Application No: BR/208/25/S73
Site Address: 1A Normanton Avenue Bognor Regis PO21 2TX
Description of works: Variation of condition 2 imposed under BR/49/25/HH relating to approved plans.

Thank you for your internet representation made on 29th December 2025 which has been recorded as an objection with the comments as follows:

SITE PLAN - 1/500

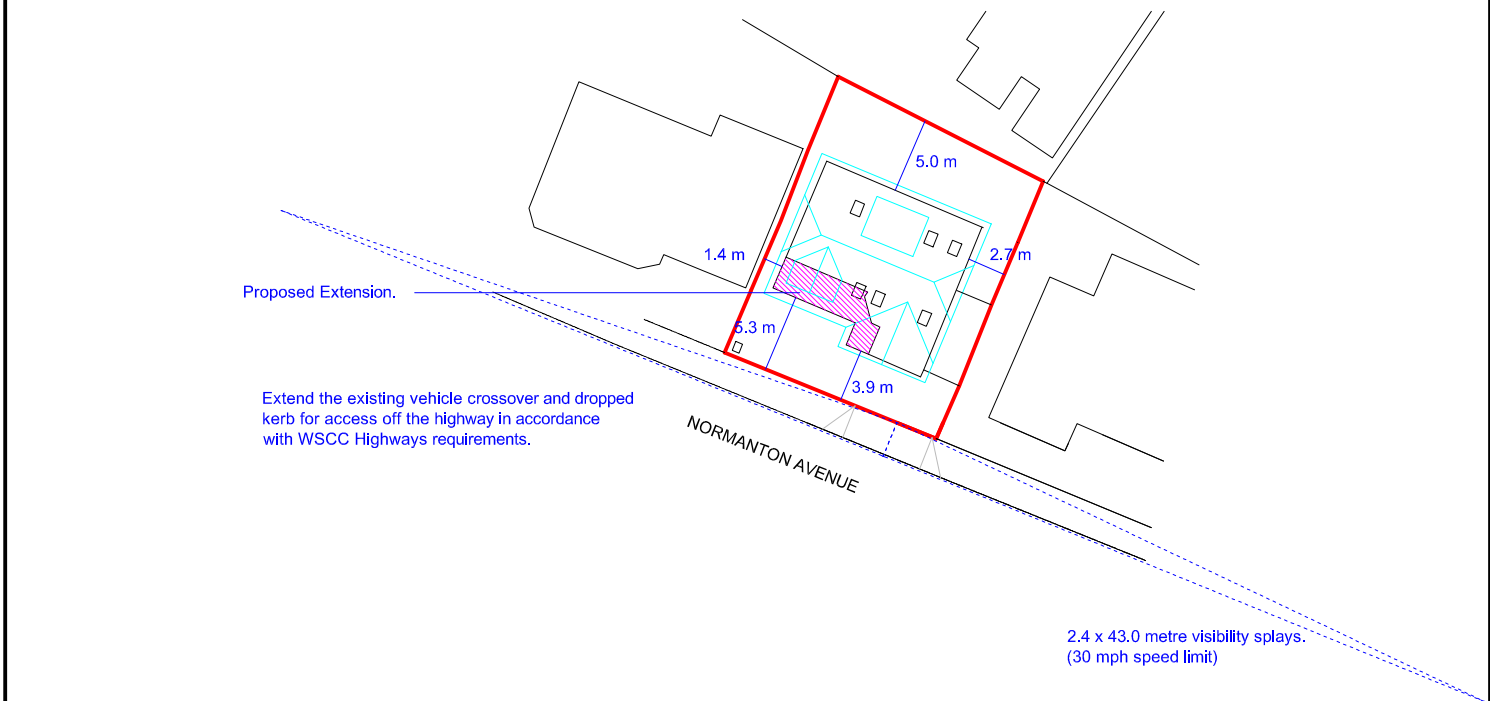
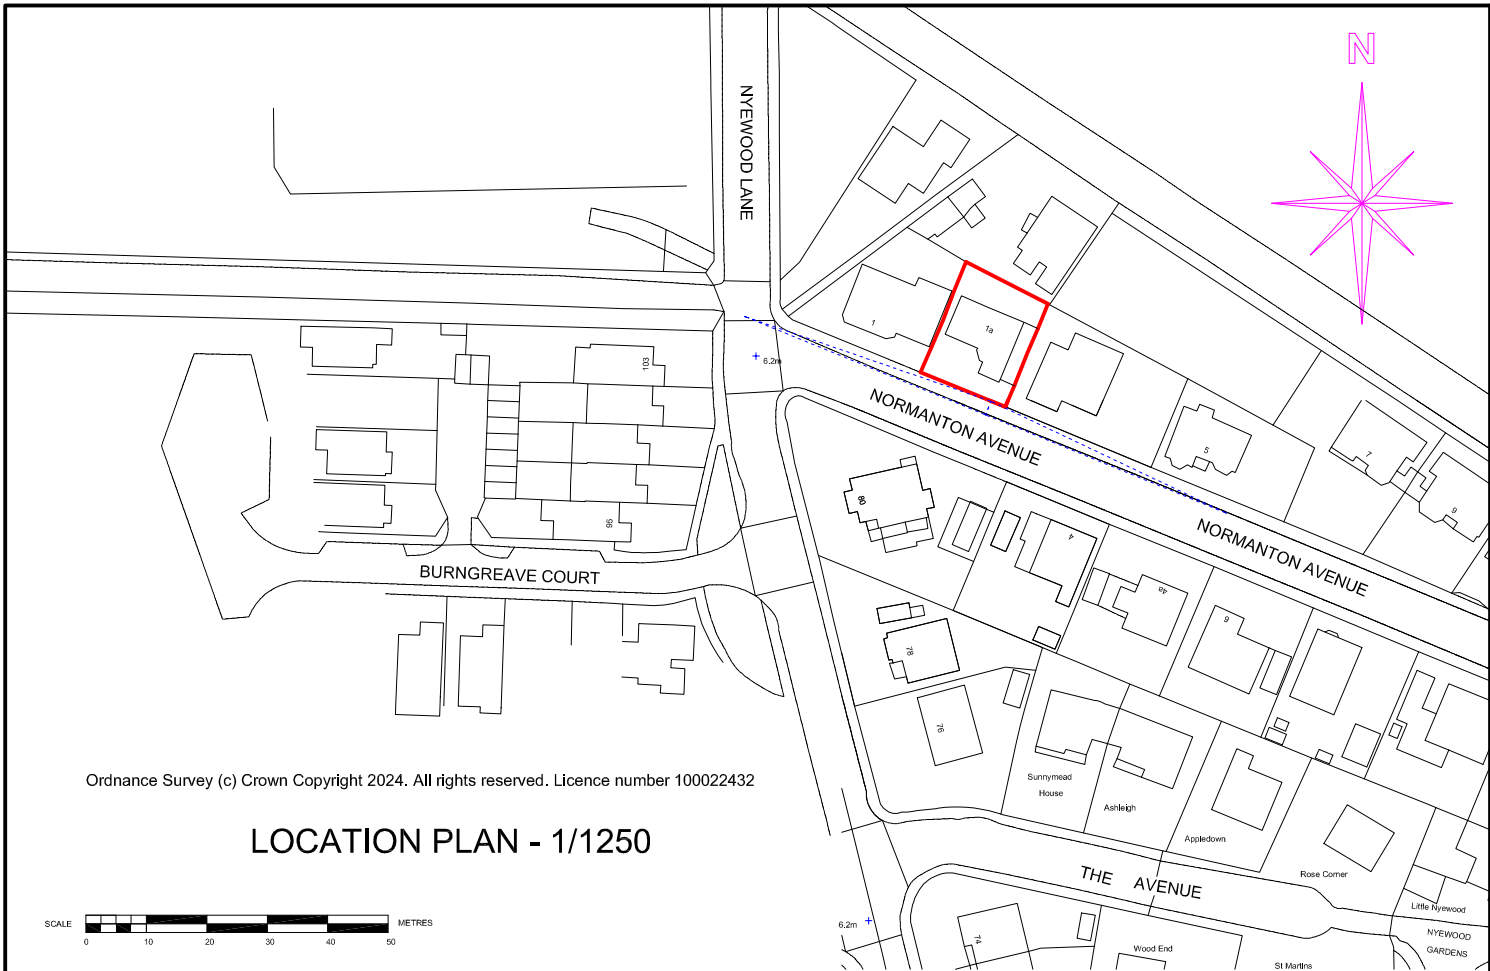
The main reason we object to the proposed change for parking is that it doesn't seem feasible for a standard sized saloon car to fit onto the space being designated, at the angle shown, without overhanging the public pathway. In fact the owner's two vans are considerably longer than a car and already overlap the path when parked in front of what was the original garage. There is also the issue that the existing dropped Kerb will not be sufficiently wide enough for a car/van to access the new space without bumping up the kerb if a car is already parked on the drive.
